**WELWYN HATFIELD BOROUGH COUNCIL
DIRECTORATE OF STRATEGY AND DEVELOPMENT**

DELEGATED APPLICATION

Application No: 6/2016/0796/HOUSE
Location: The Limes, 51 High Road, Essendon, Hatfield, AL9 6HS
Proposal: Erection of greenhouse following demolition of existing greenhouse
Officer: Mr A Mangham

E3200 Figgis: Floor plan

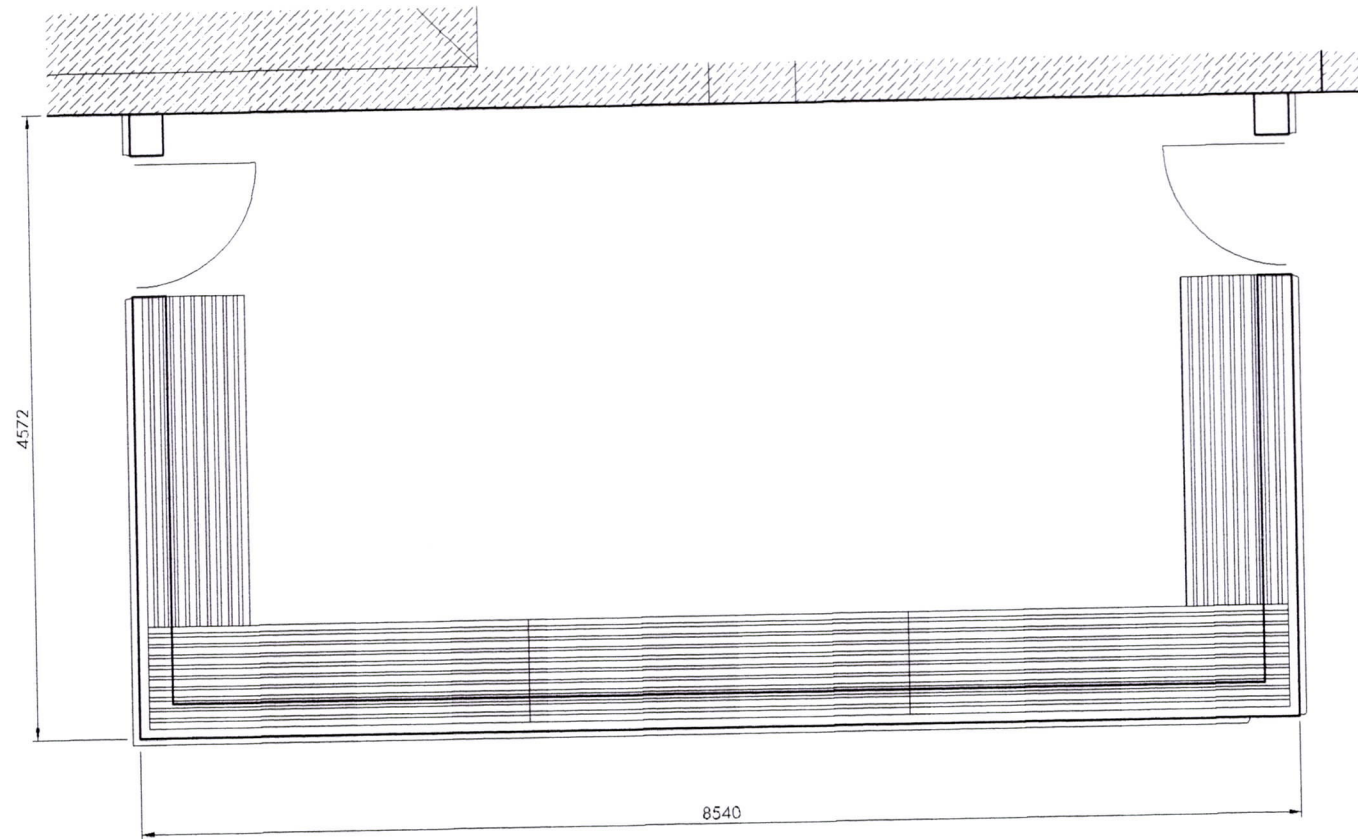
attaching to this fixture. With regard to the foundation design issue highlighted the submitted plans indicate no new foundations with the wall to be built from an existing masonry base.
Conclusion	
The proposed development would respect the character of the area, reflect the design of the host dwelling and maintain the amenity of the occupiers of adjoining occupiers. Accordingly, the development complies with policies D1, D2 and GBSP2 of the Welwyn Hatfield District Plan 2005, the Supplementary Design Guidance Statement of Council Policy 2005 and the National Planning Policy Framework 2012.
